Current Zoning: N1-A (neighborhood 1-A)
Proposed Zoning: INST(CD) (institutional, conditional)

The petition proposes to allow the renovation and expansion of an existing assisted living/independent living senior facility.

AGENT/REPRESENTATIVE

Walter Fields, Walter Fields Group

# RZ-2

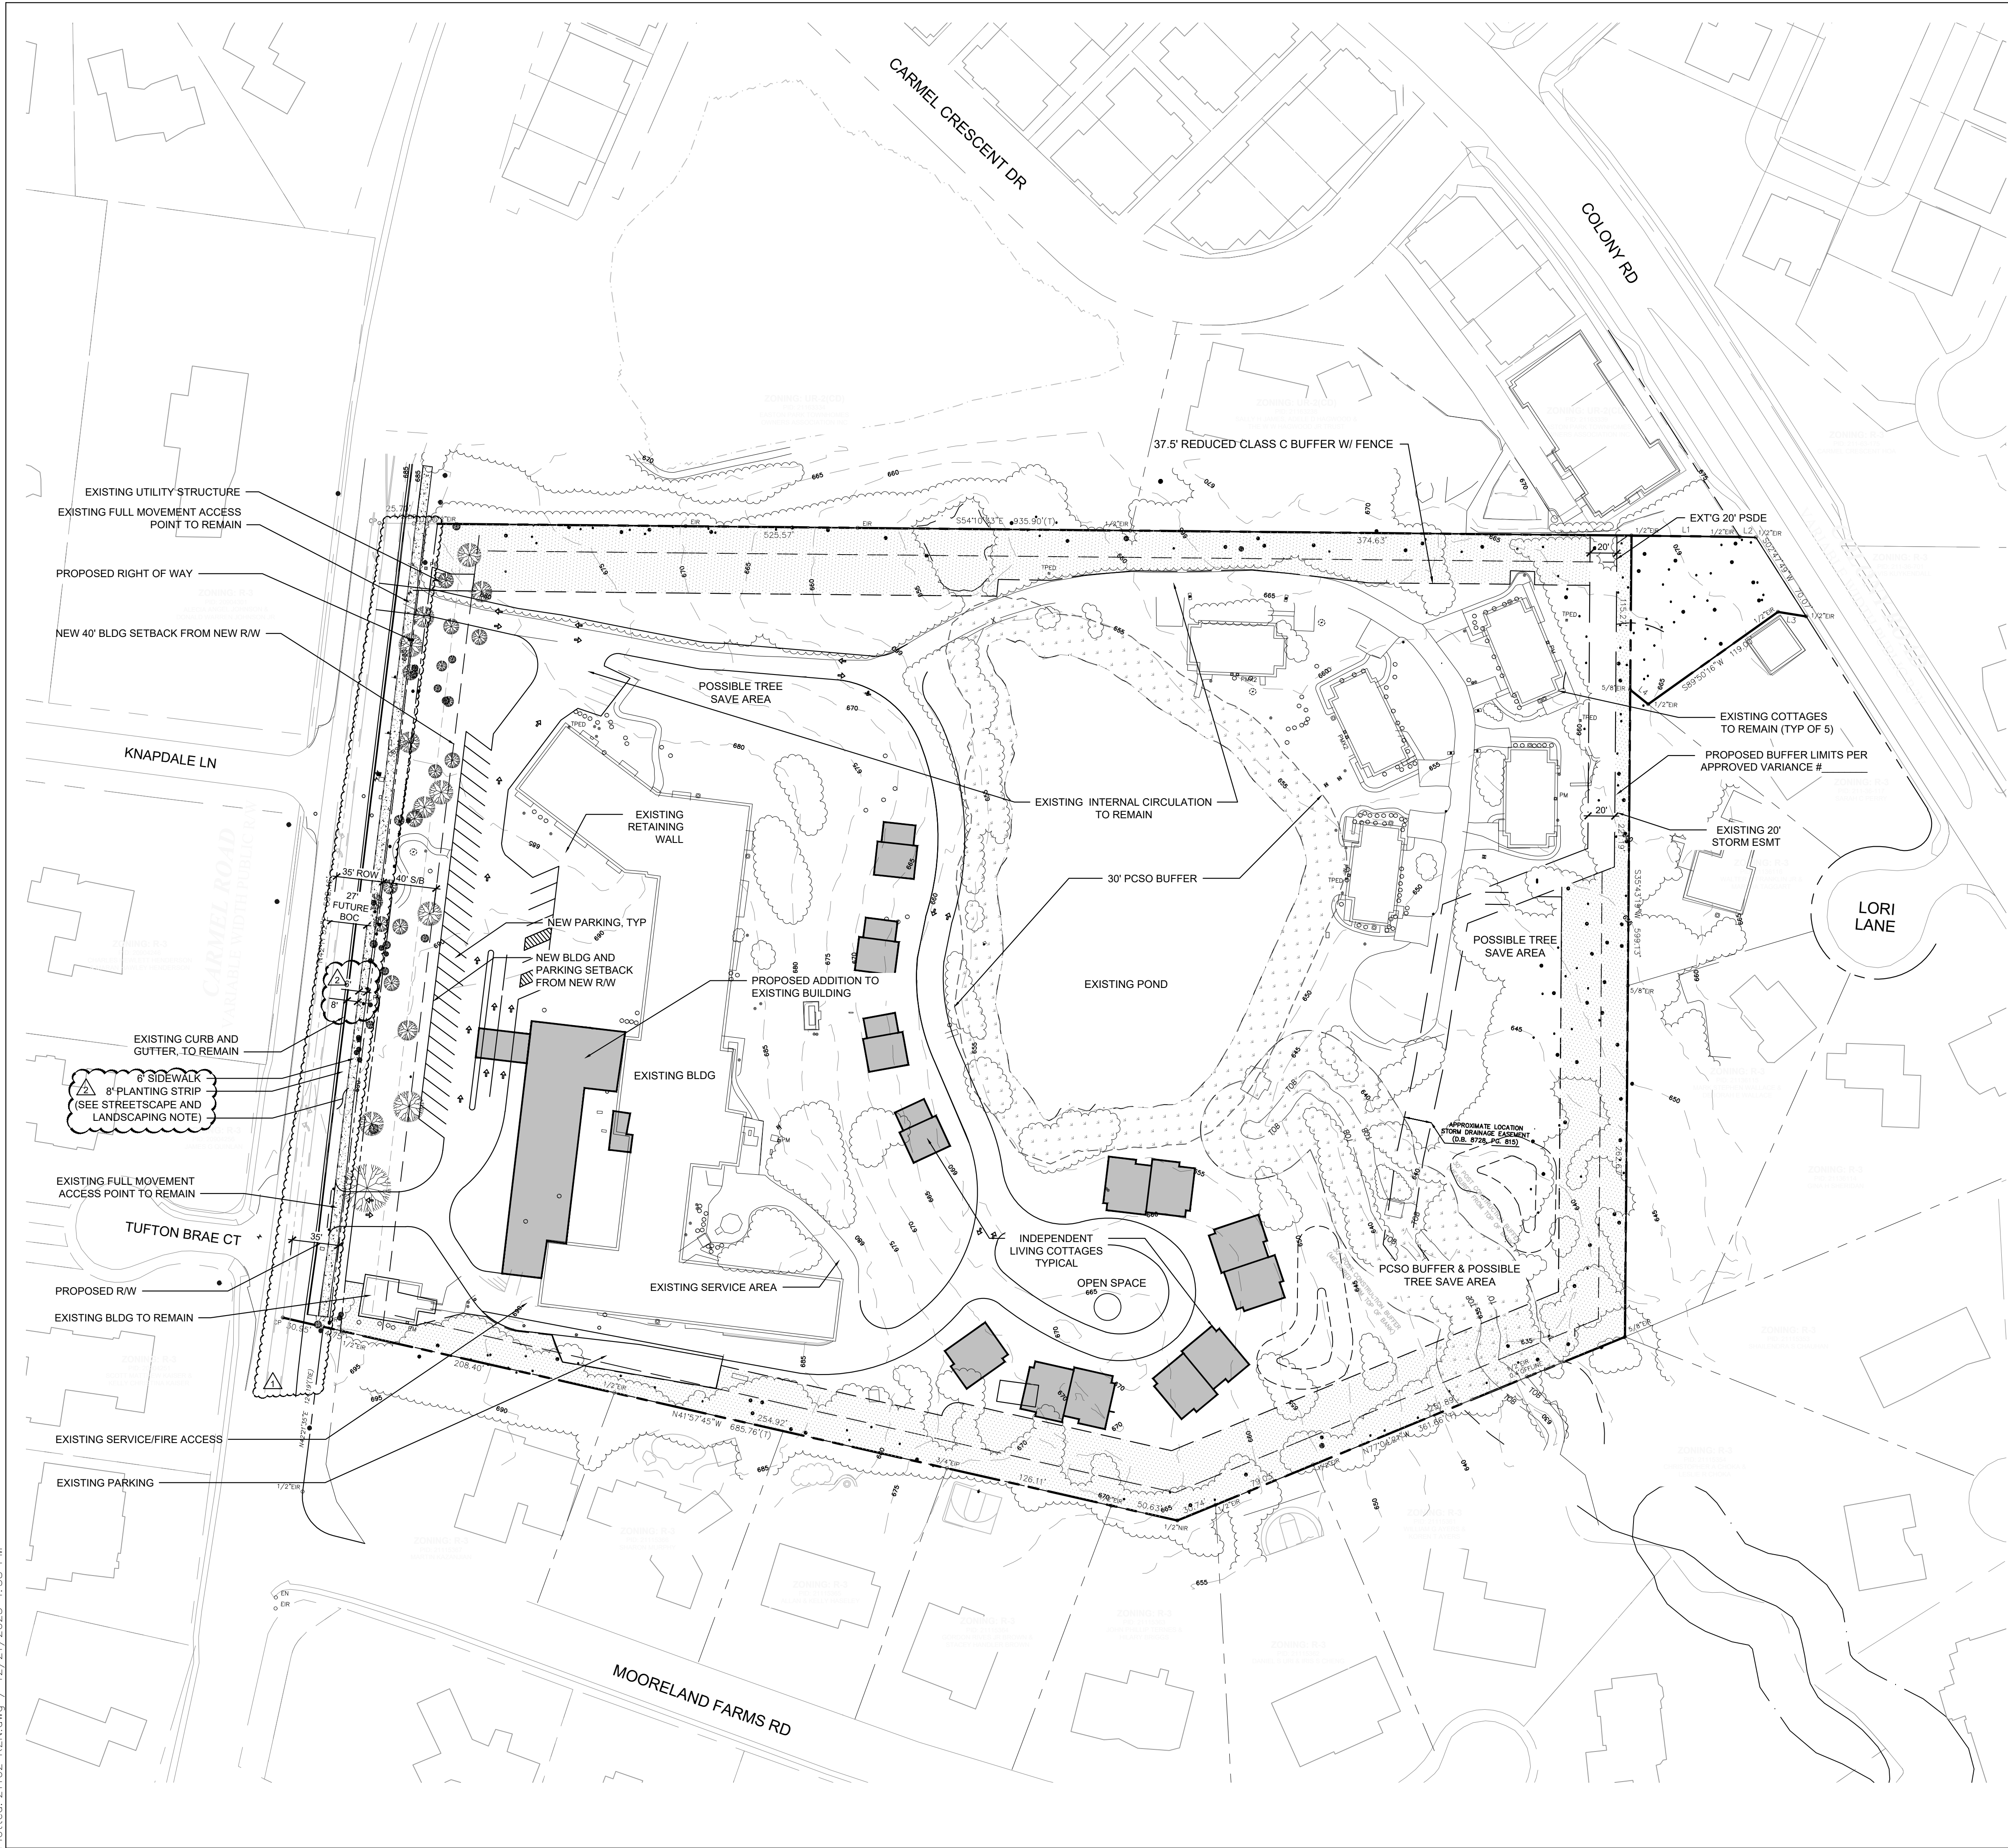
1. Colony Road: Location of future curb and gutter to be moved to 24 feet from roadway centerline to accommodate the Charlotte Streets Map with a roadway typical section of CLDSM 11.09 Minor Thoroughfare. Per Chapter 19 revise site plan and conditional note(s) to commit to construct an 8-foot planting strip, and 6-foot sidewalk on Carmel Road and Colony Road.

2. Revise site plan and conditional note(s) to commit to dedicate 43 feet of right-of-way from the Carmel road centerline and 40 feet of right of way from the Colony Road centerline. The site plan shall label and dimension the right-of-way from the road centerline.

3. Request to revise site plan and conditional note(s) to commit to construct a buffered bicycle facility along Carmel Road by locating the back of curb and gutter 27' from the center line to meet the Council-adopted Charlotte BIKES Policy.
